**Consultation Response from KC,
Lead Local Flood Authority**

**2020/92067 former, Stile Common Infant & Nursery School, Plane Street, Newsome,
Huddersfield, HD4 6DF**

Erection of 30 dwellings

**Date Responded:
12 January 2021**

TITLE	SITE ACCESS LONGITUDINAL SECTION	
PROJECT	PLANE STREET, HUDDERSFIELD	
CLIENT	ACCENT HOUSING GROUP	
DRAWING STATUS	PRELIMINARY	
Scale	H1:100 V1:500	Date 13.10.20
Drawn	RJ	Chk. MI
Drg. No.	1375-02-06.01	Rev B

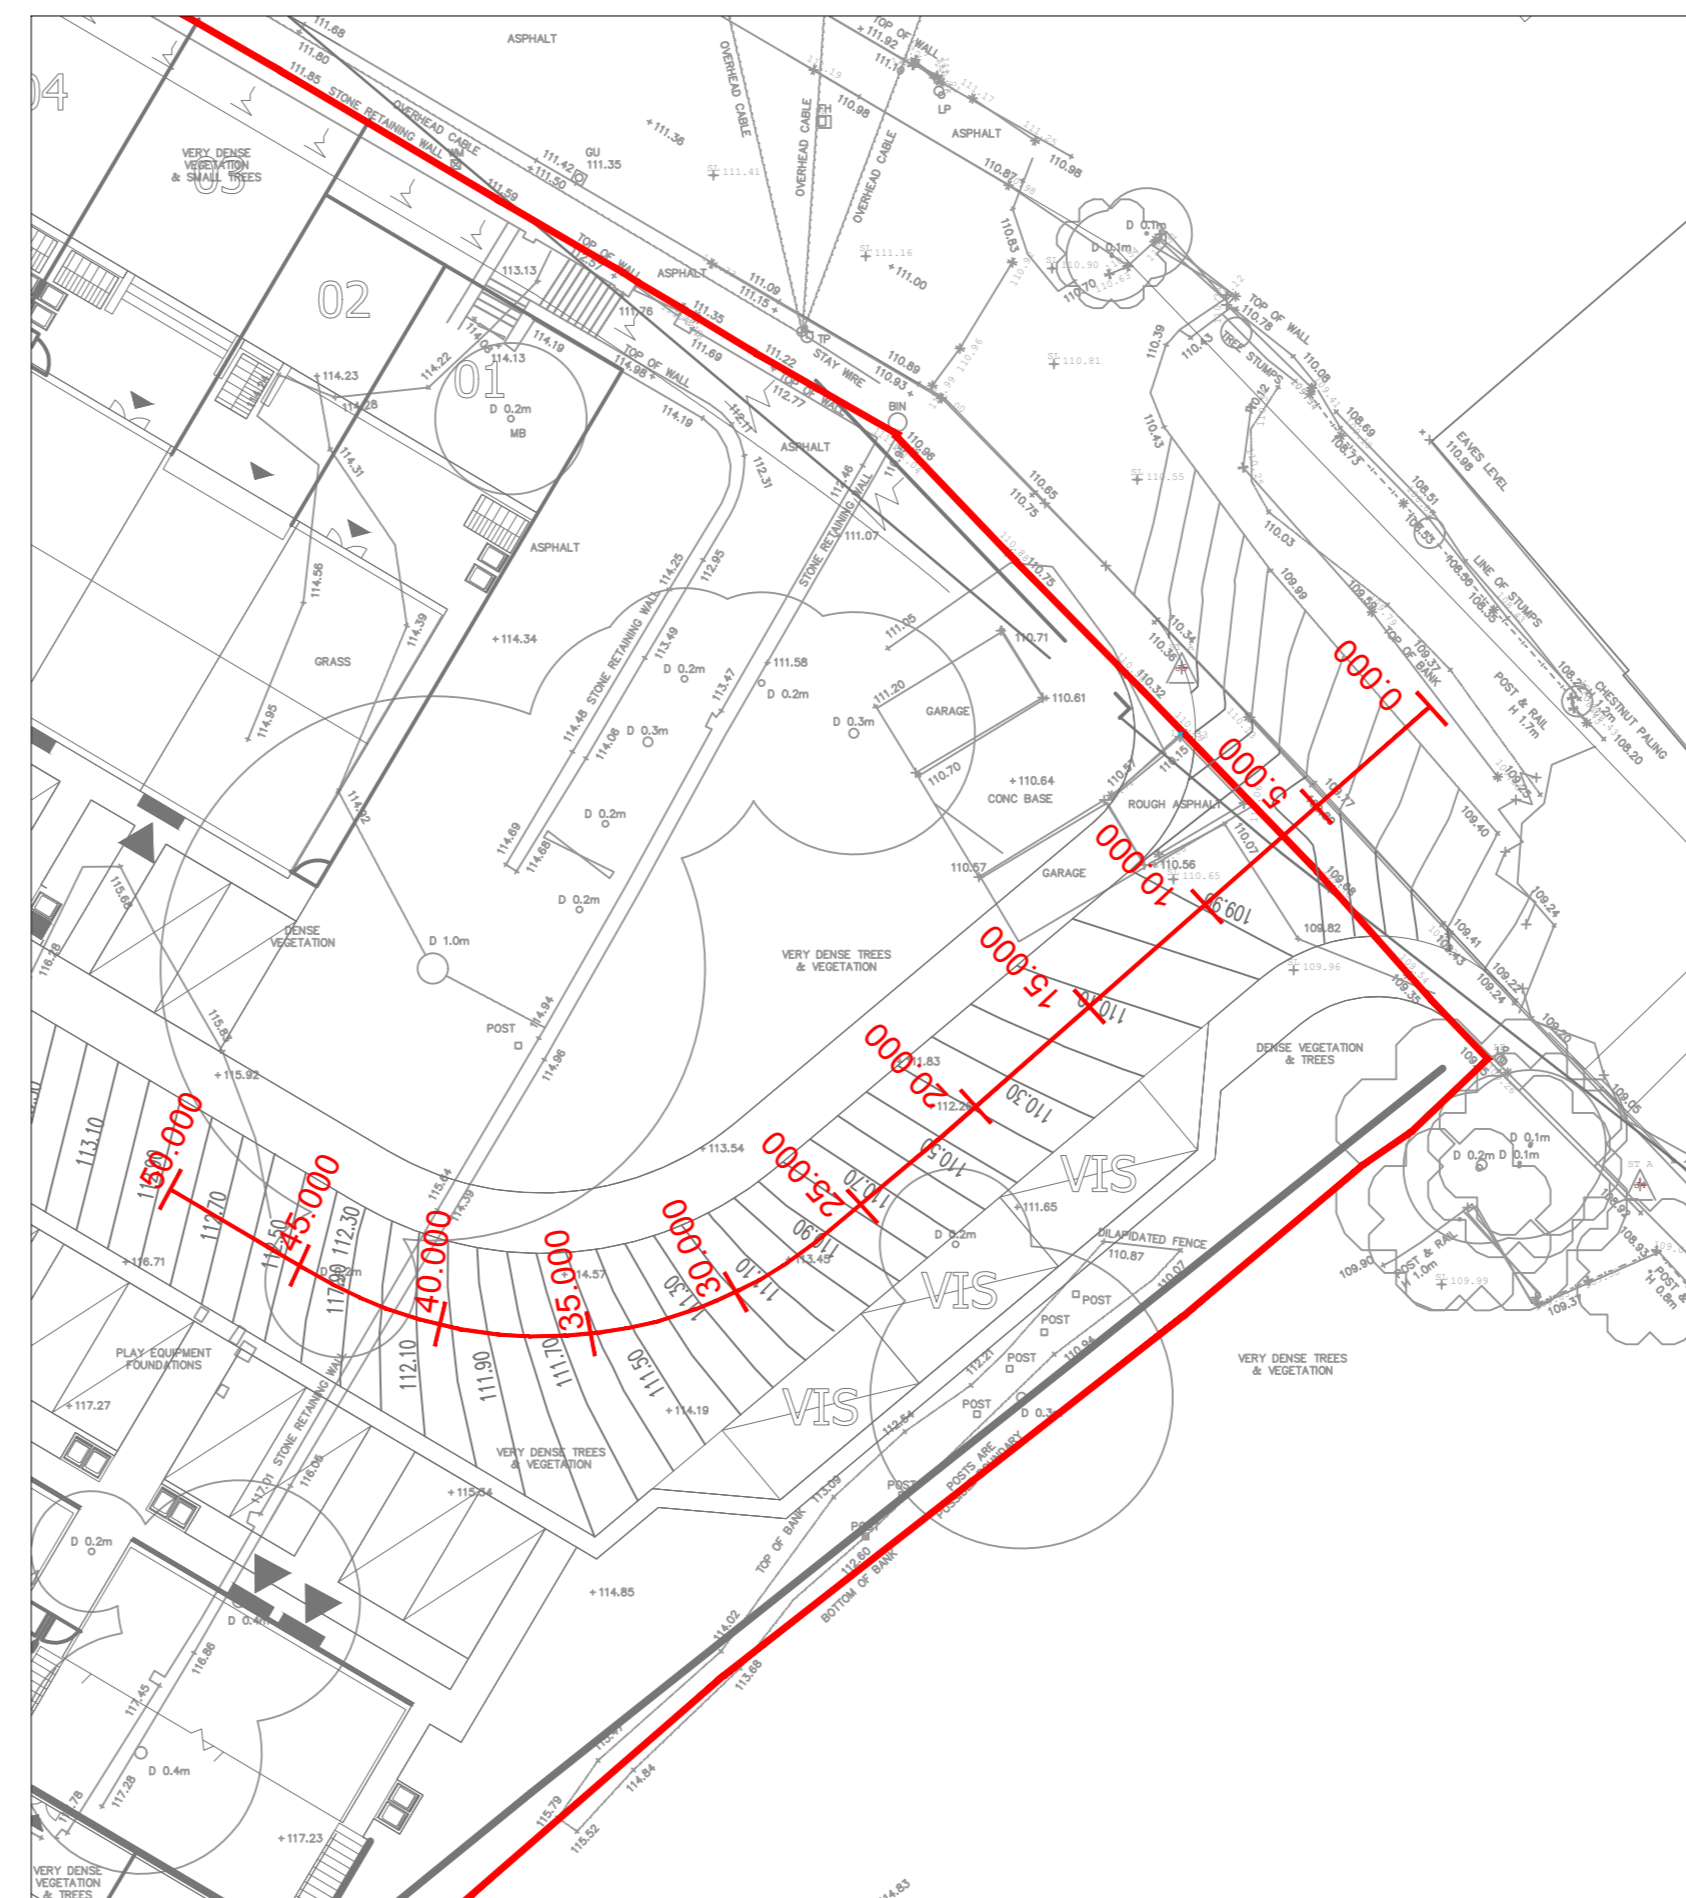
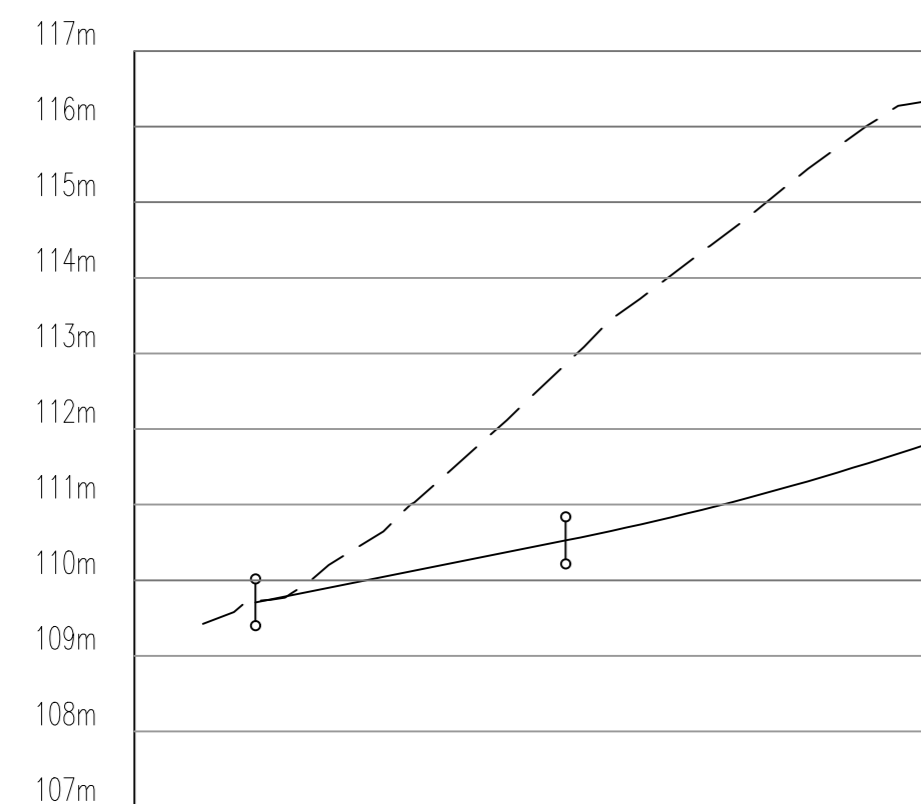
- *Section 104 Layout* drawing, prepared by ARP Associates, number 1375/02/03, revision A, dated 30.09.20;
- *Site Access Longitudinal Section* drawing, prepared by ARP Associates, number 1375-02-06.01, revision A, dated 04.12.20;
- *Impermeable Area Plan* drawing, prepared by ARP Associates, number 1375-02-09, dated 09.09.20;
- *Flood Exceedance Route* drawing, prepared by ARP Associates, number 1375/02/10, dated 09.09.20;
- MicroDrainage outputs, prepared by ARP Associates, dated 04/12/2020; and
- MicroDrainage outputs, prepared by ARP Associates, dated 11/06/2020.
